CITY OF ALBUQUERQUE

July 10, 2017

**RE: Ladera Crossing Self Storage
Grading Plan
Stamp Date: No Stamp Date
Hydrology File: J09D026**

Based upon the information provided in your submittal received 6/30/2017, the Grading Plan **is not** approved for Building Permit. The following comments need to be addressed for approval of the above referenced project:

### CONCEPTUAL GRADING AND DRAINAGE PLAN

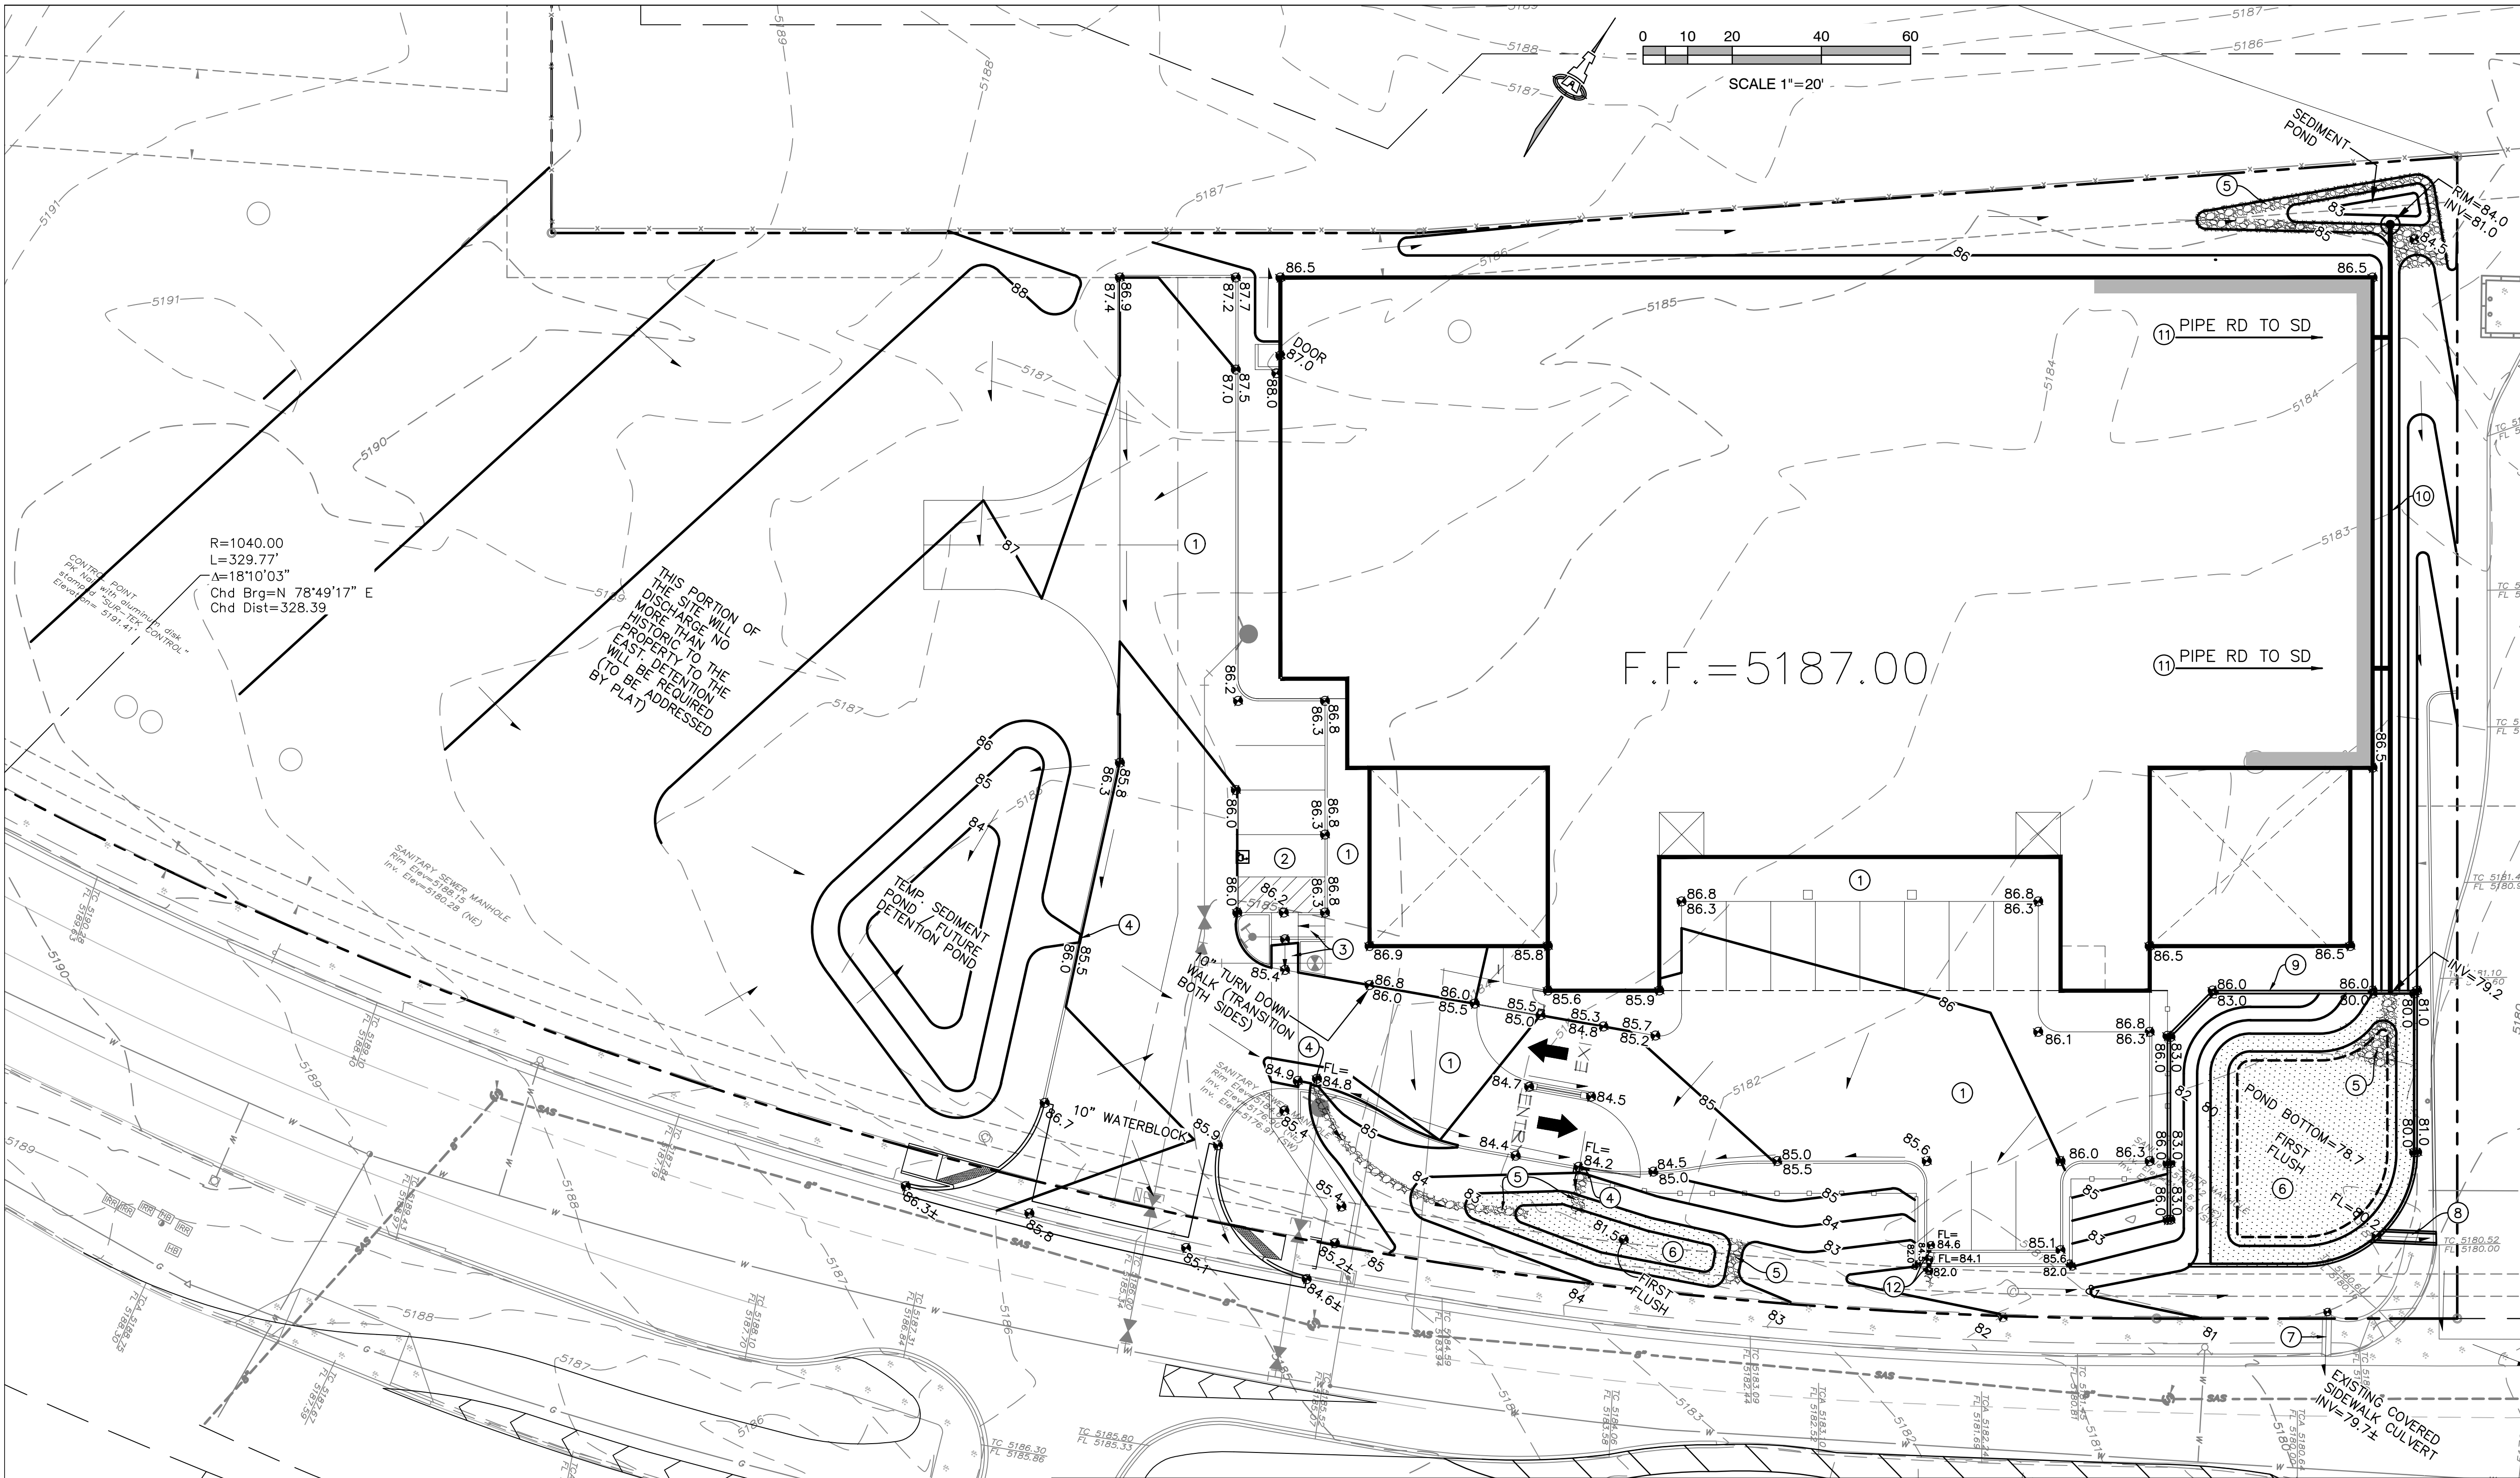
2. Please provide an engineer's stamp with a signature and date.
3. Please remove the word "Conceptual" from the sheet title. A grading and drainage plan is needed for a building permit.

4. This site was included in a drainage study entitled, "Ladera Drive Improvements Gavin Road to Coors Boulevard – Drainage Analysis Memo" by Parsons Brinckerhoff dated August 10, 2015. Please reference this study on the sheet.

5. Please provide the first flush calculations and show each pond volume on the plan at each pond.
6. Please provide the calculation for the sizing of the sedimentation pond at the northeast corner of the site.

7. Please provide the calculation for the sizing of the temp sedimentation/future detention pond.
8. Please provide the weir calculations for the curb cuts.
9. Please provide the pipe size and pipe slope of the proposed drain pipe that connects the sedimentation pond at the northeast corner of the site to the first flush pond in the southeast corner of the site.
10. Please provide the proposed grades at the retaining wall along the south section of the first flush pond in the southeast corner of the site.
11. Please provide a typical detail for the turned CMU block. This block needs to be at least four (4) inches above the proposed grade to avoid clogging.
12. Please provide a Private Facility Drainage Covenant per Chapter 17 of the DPM.
